Nestle Hayes  
Schedule 2 - Response to Consultation  
17 August 2017

Drawing 642.11.02 Revision

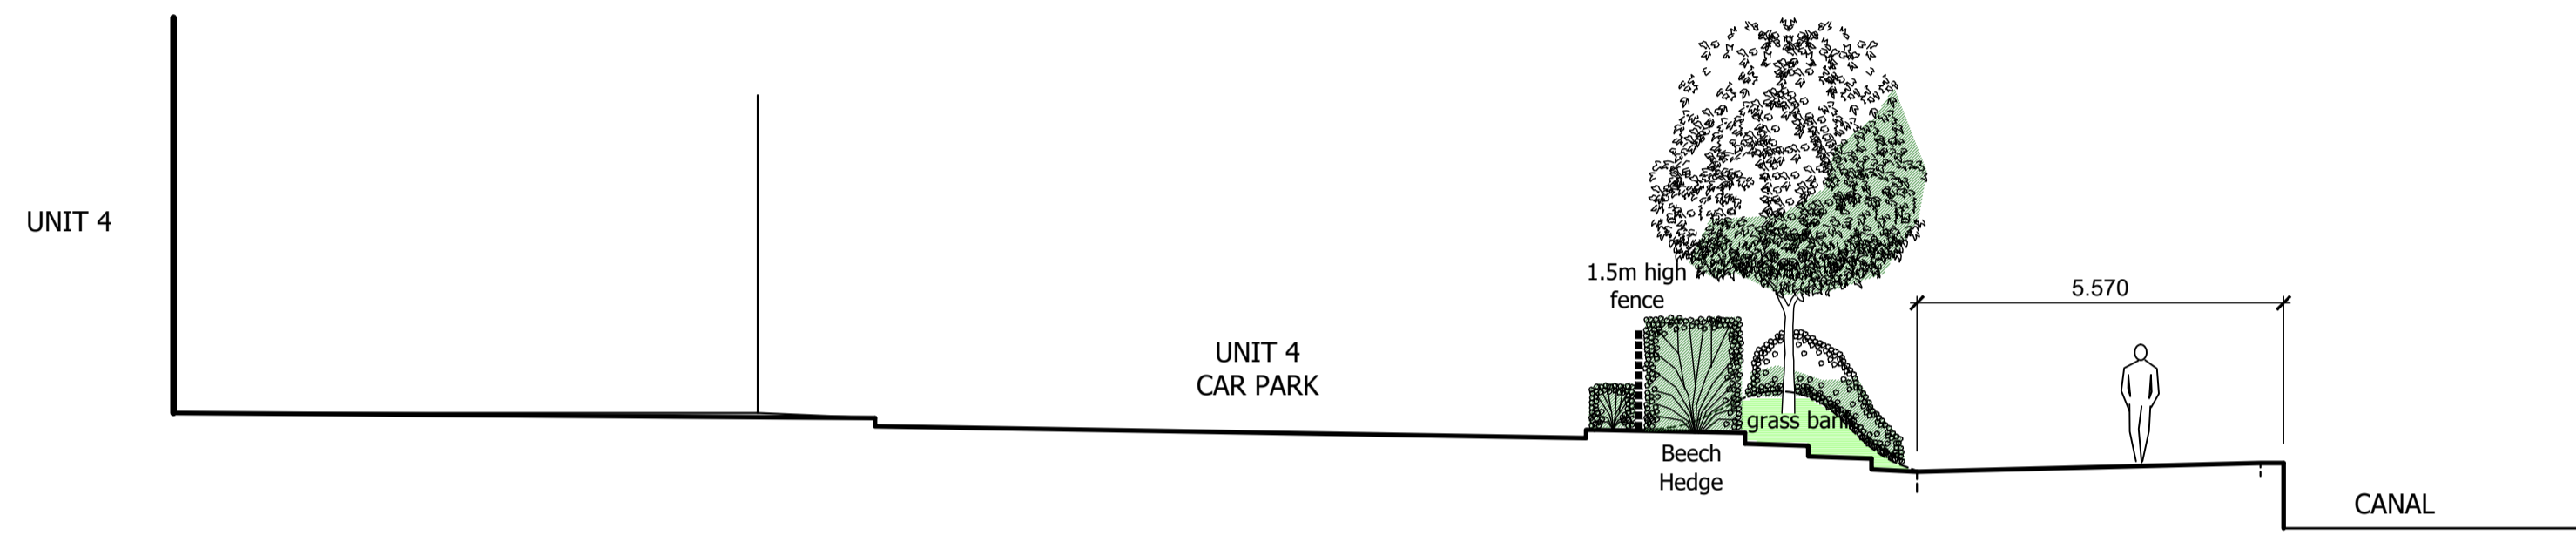
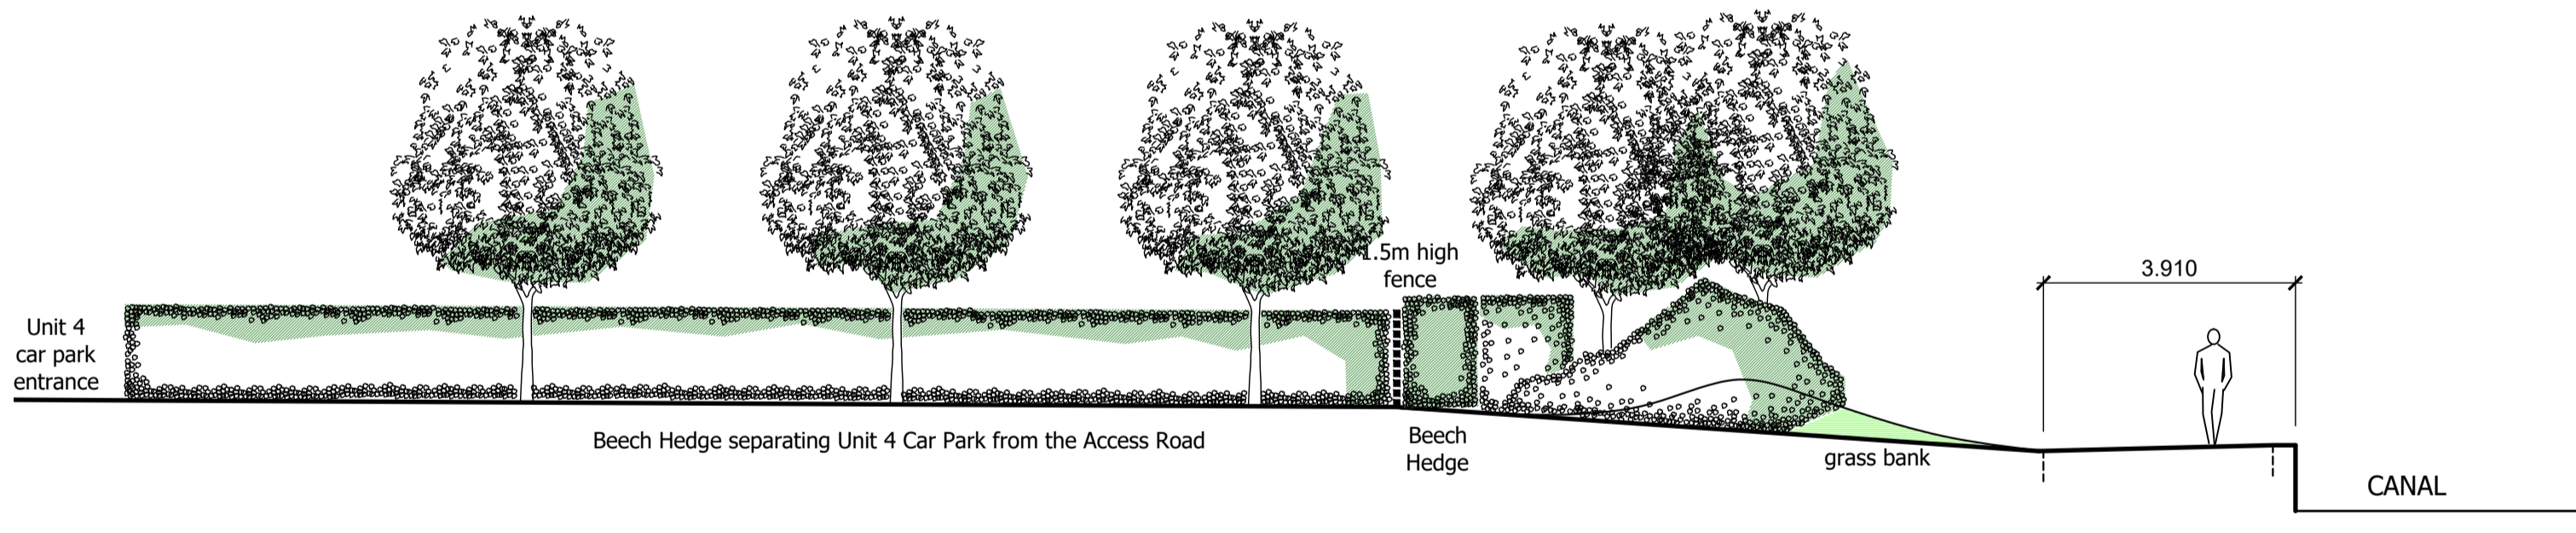
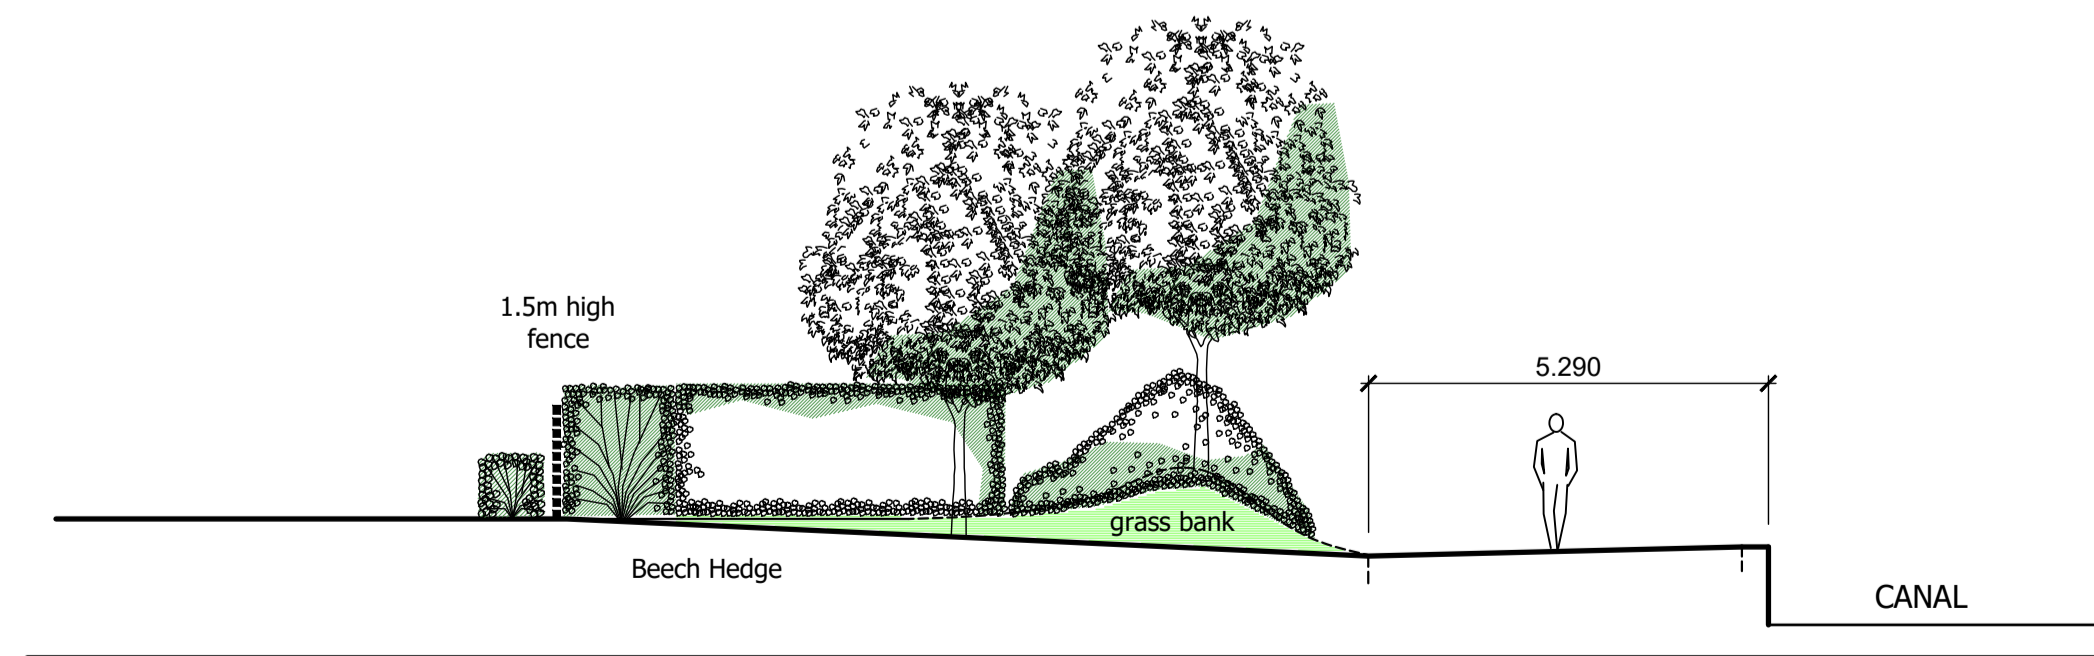
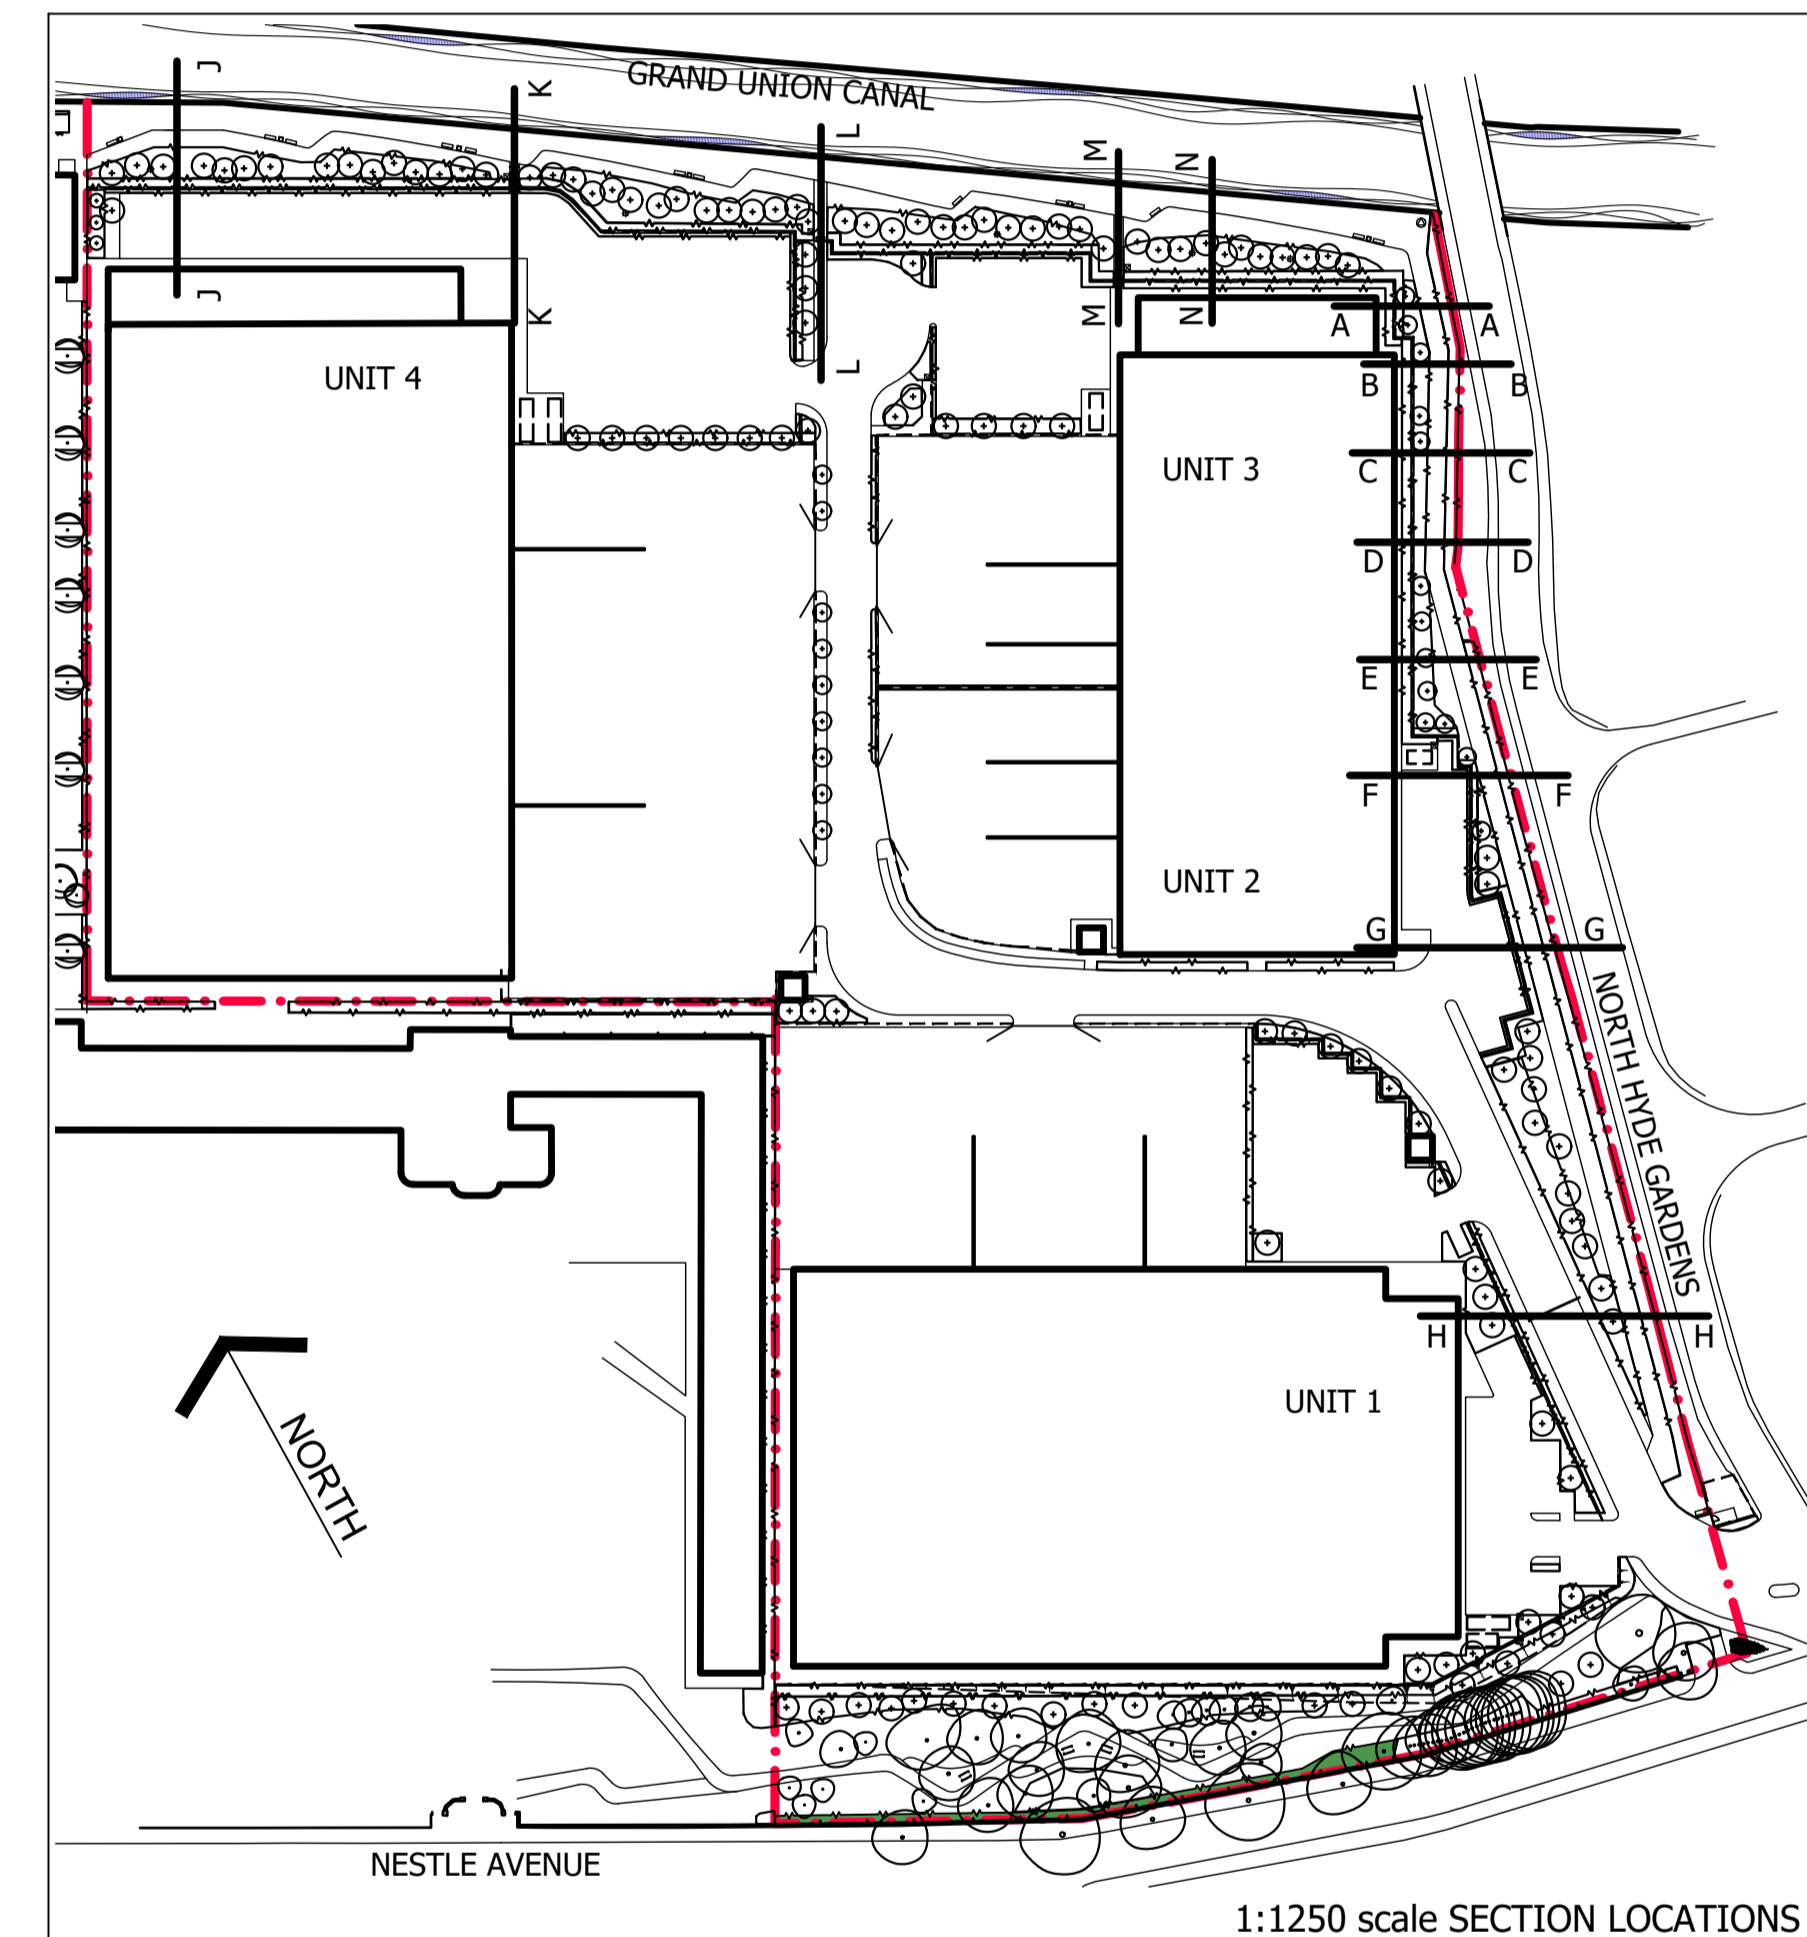
Moorings	Team to explain process that has been engaged to accommodate moorings and justify what is proposed.					Further meeting to be held with Canals and Rivers Trust - response to follow.
<b>Gillespies/TALA</b>						
Canal	Team to provide sections of relationship of landscaped area with canal		YES	YES		See TALA drawing 642.11.02
Trees in Wallis Gardens	Gillespies/Aspect to respond on concern with the retention/impact on trees adjacent to the south west part of Block G.					See Gillespies sketchbook 12 pack
Tree Pits	Gillespies to provide tree pit details					See Gillespies sketchbook 12 pack
Greening of Industrial Scheme	TALA to respond on the concern that the commercial service yards aren't green enough. LBH has also asked for living walls and living roofs. We need a comprehensive response on these matters as it was clear that officers were of the view that more could be done to "green" the commercial proposals. This point was reiterated in the context of the proposed data centre use. LBH members are switched on to the fact that ~10% of the carbon footprint of the Borough is created by datacentres, so in order to ensure the commercial scheme is sustainable, the proposals should "go over and above" to ensure its green credentials					Response to follow
